Appendix A1: Summary of Consultation Responses to Planning Application (3/2021/0661)

**Haweswater Aqueduct Resilience Programme - Proposed Marl Hill
Section**

Project No: B27070CT
Document Title: Proposed Marl Hill Section, Supplementary Environmental Information
Appendix A1: Summary of Consultation Responses to Planning Application
(3/2021/0661)
Document Ref.: RVBC-MH_SEI-A1
Revision: 0
Date: January 2022
Client Name: United Utilities Water Ltd

SCALE N.T.S.	SHEET SIZE A3
DRAWING NUMBER RVBC-MH-APP-004-12_07	REVISION 1

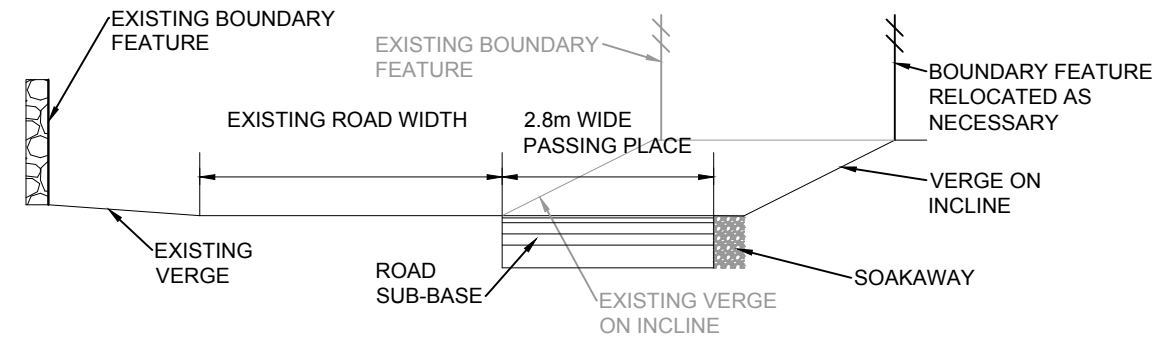
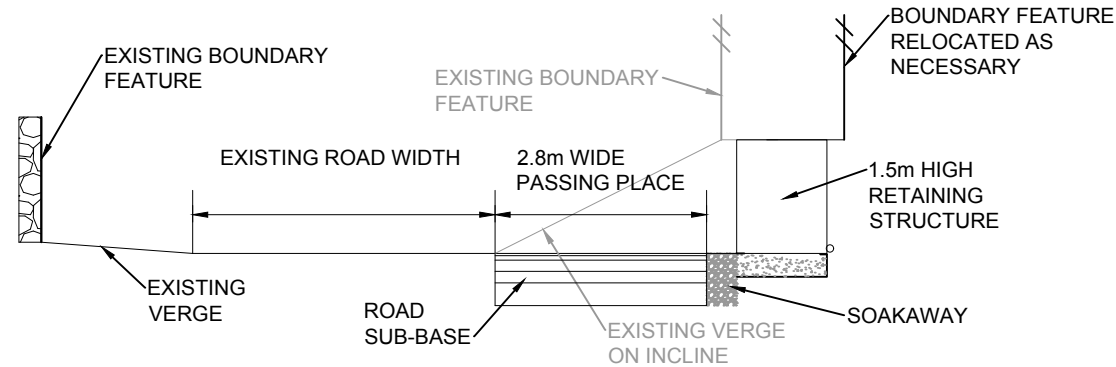
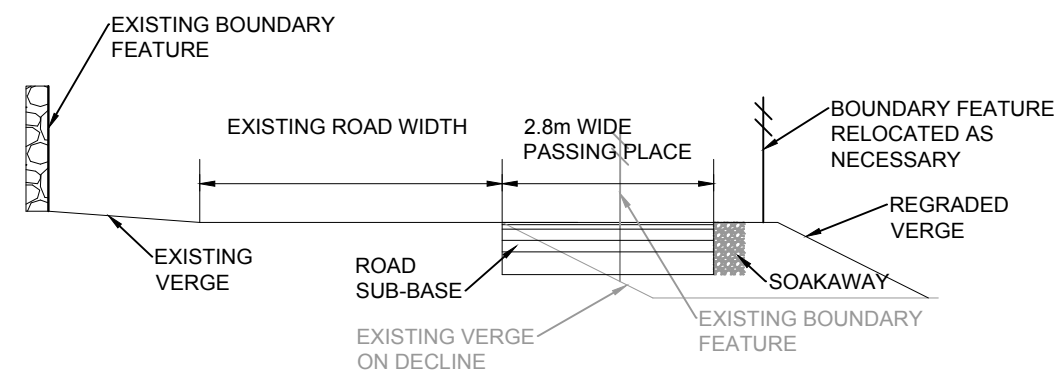
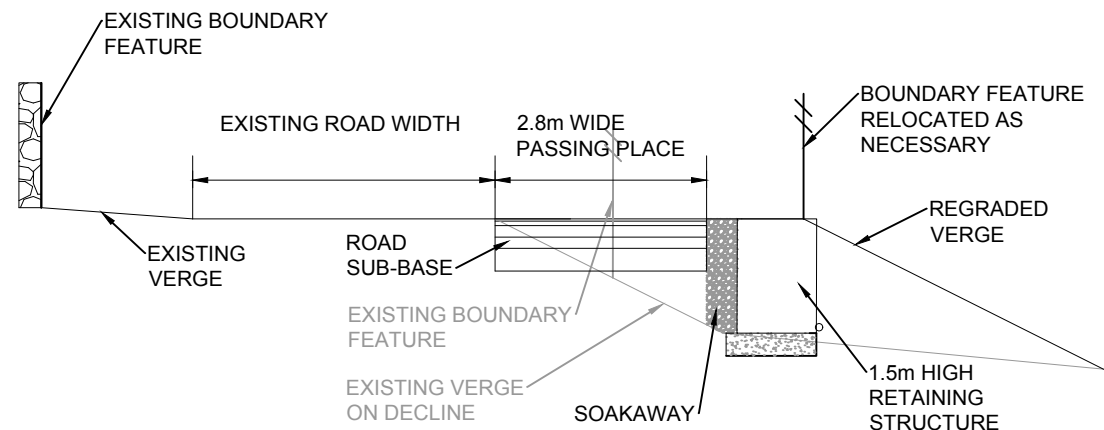
Resp No.	Consultation Response Text	United Utilities Response	Action
	the road widenings, in the placement of places. This information is currently not provided but required.		
MH 13	A59 traffic may lead to increased delays for users but it may also impact on safety. The applicant must identify the impacts on safety at this location and provide a safe and suitable solution, if required.	A road safety audit of the junction of the A59 and Pimlico Link Road, taking into account additional HGV movements associated with the proposed development, will be carried out and United Utilities commits to implementing the findings of the audit in accordance with a suitably worded planning condition.	
MH 14	Lack of modifications for the access route via Waddington centre	The CTMP has been updated to provide detail relating to traffic management proposals on West Bradford Road at the north of Waddington. Haulage Route Option 2 (the Ribble Crossing) has been adopted as the proposed route for construction traffic access to the Braddup and Bonstone compounds and as a result the route through Waddington from Clitheroe would only be utilised during the enabling works phase to facilitate construction of the Ribble and Hodder Crossings. The CTMP has been updated to account for this.

SCALE N.T.S.	SHEET SIZE A3
DRAWING NUMBER RVBC-MH-APP-004-12_08	REVISION 1

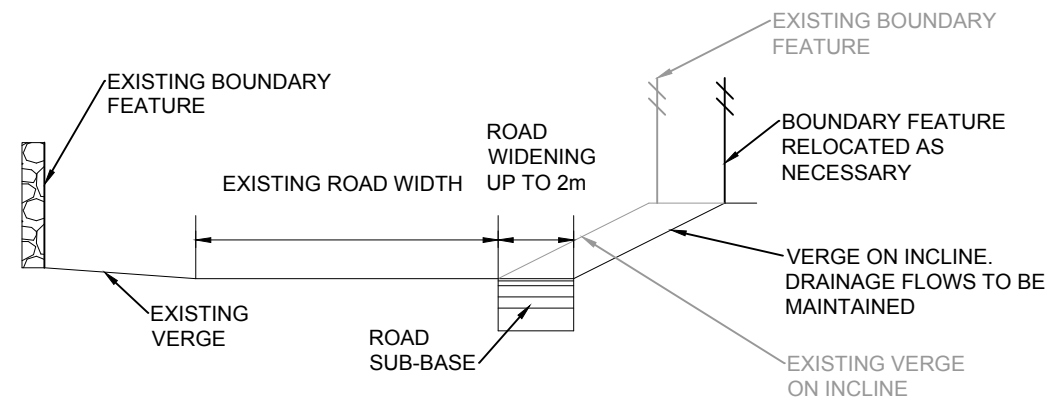
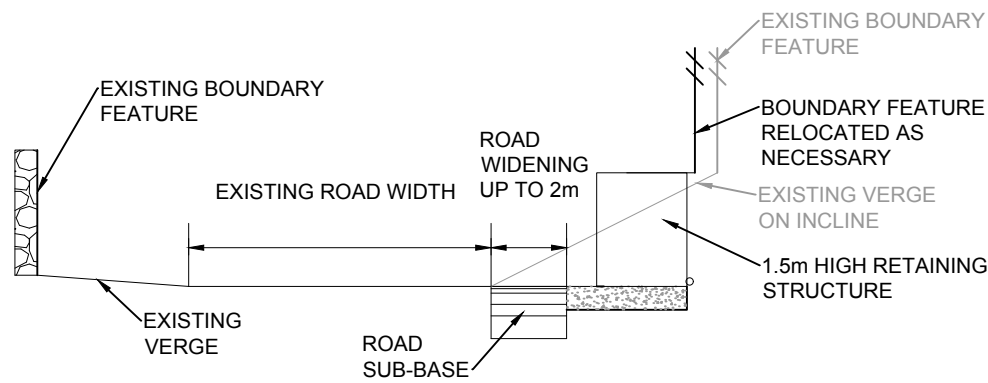
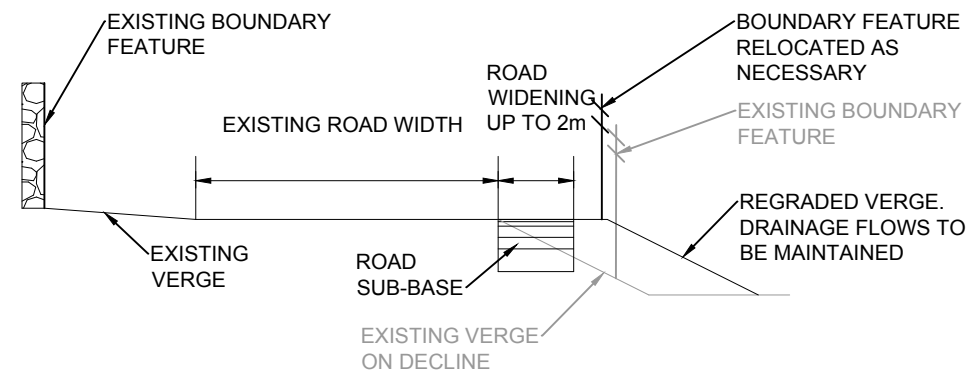
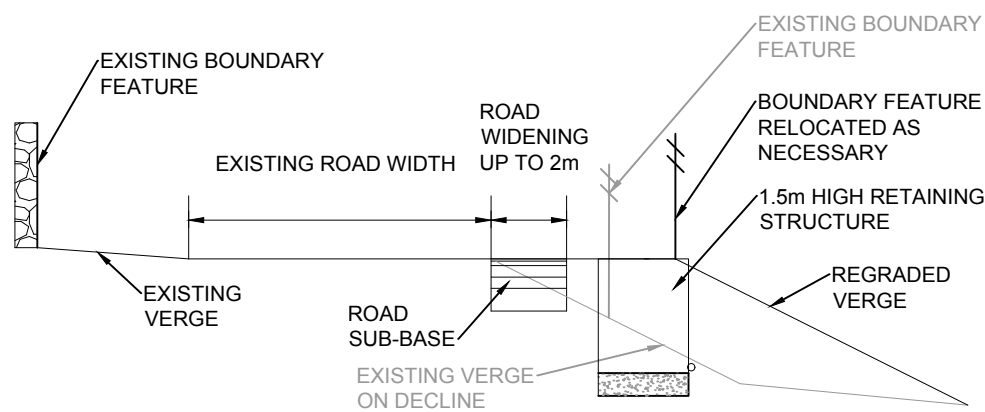
Resp No.	Consultation Response Text	United Utilities Response	Action
	issues do not appear to be shown or highlighted in the proposals, nor any solution proposed.		
MH 18	Comments relating to road widening proposals RW01 to RW07	Haulage Route Option 2 (the Ribble Crossing) has been adopted as the proposed route for construction traffic access to the Braddup and Bonstone compounds and as a result road widening locations RW01 to RW07 are no longer proposed in the planning application. Haulage Route Option 1 would only be used for a short term period of approximately 9 months during the enabling works to facilitate construction of the Ribble and Hodder Crossings. The route through Chatburn, Grindleton and West Bradford would only be utilised by exception and no more than 4 HGVs per day would be permitted to use the route. Further information regarding the traffic management controls to be implemented during this period are set out in the updated CTMP.
